Application No: Y/146/20/RES
Site Address: Land at Street Buildings North End Road Yapton BN18 0DT
Description of works: Application for approval of reserved matters for the erection of 45 dwellings pursuant to Section 73 permission Y/13/18/PL (following the grant of outline planning permission Y/49/17/OUT) (resubmission following Y/39/20/RES). This application may affect the setting of a Listed Building.

Thank you for your internet representation made on 16th January 2021 which has been recorded as an objection with the comments as follows:

Title:
ENCLOSURES PLAN

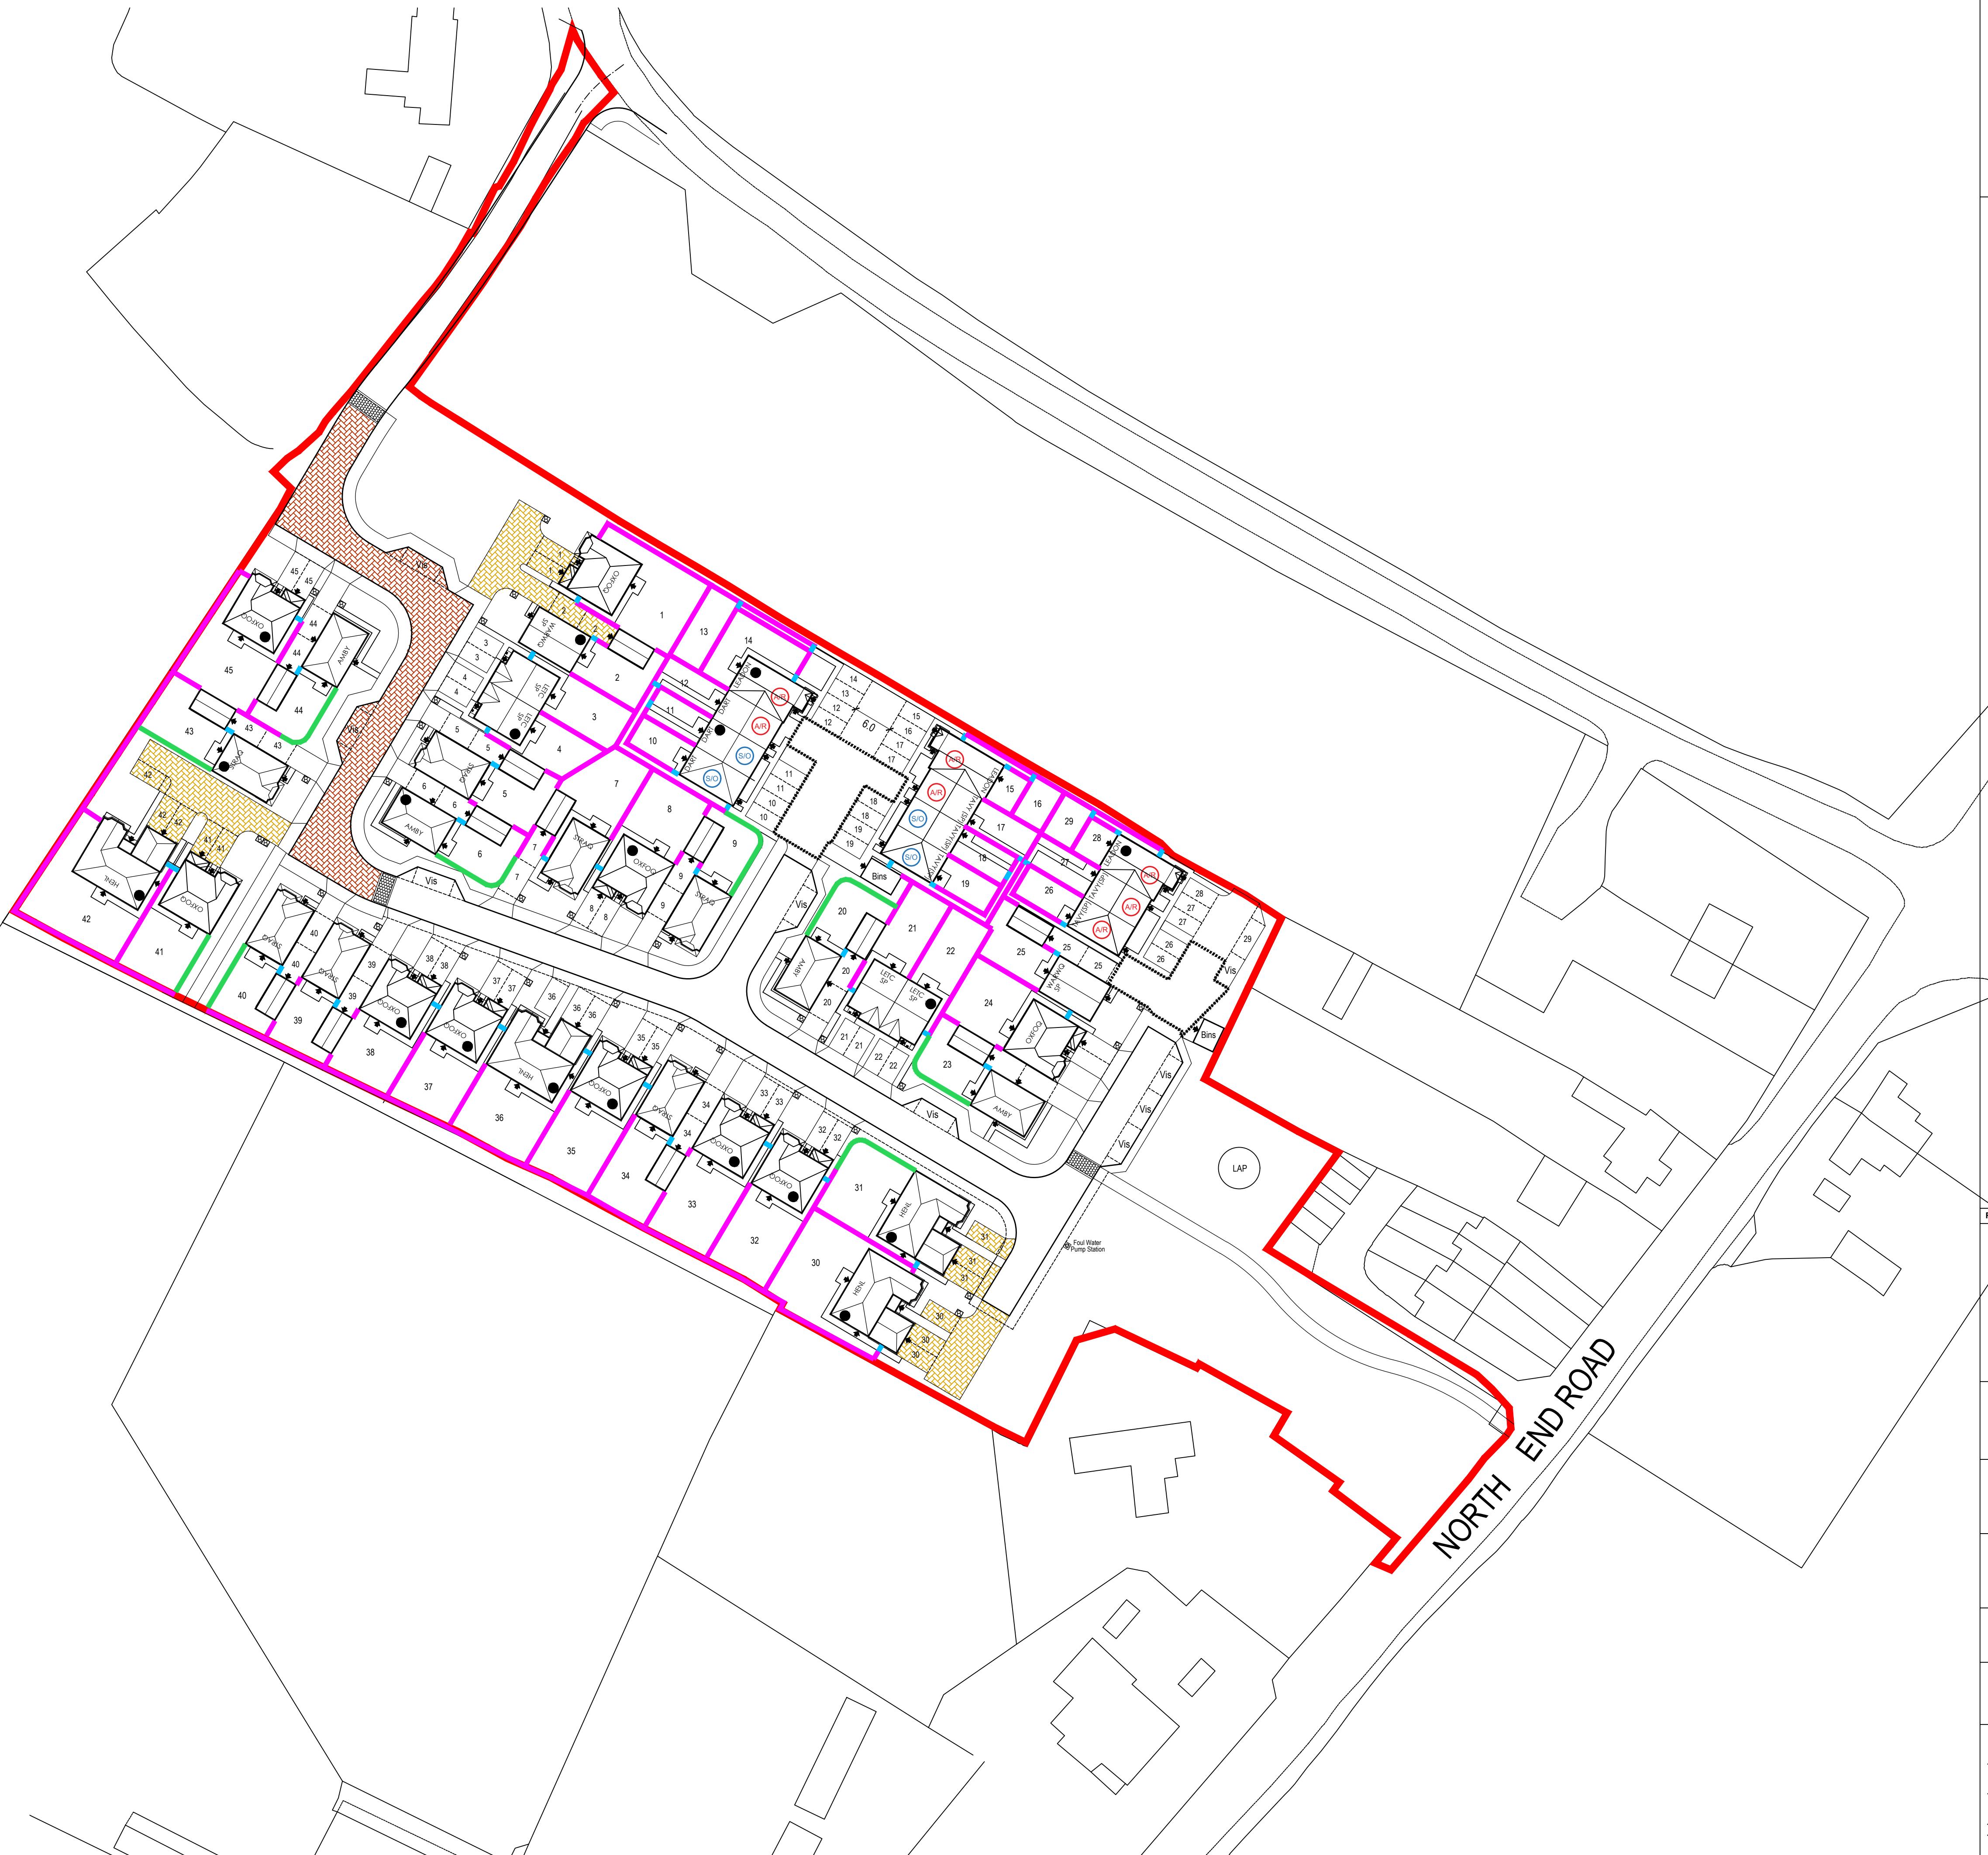
Having looked at the documents with this application I am not clear what is planned for the boundary between our land and the pedestrian exit onto North End Road. Our suggestions would include hedging or fencing which is tall enough to create a barrier, but which does not block out all light; use of the current stables building materials (which are due to be demolished) to build a short flint wall with hedging above etc. We would also like to discuss the construction process as we work from home, so the noise and disruption will have a significant impact on us. We would like to have some direct discussions with Redrow on this matter, and hope they will contact us.
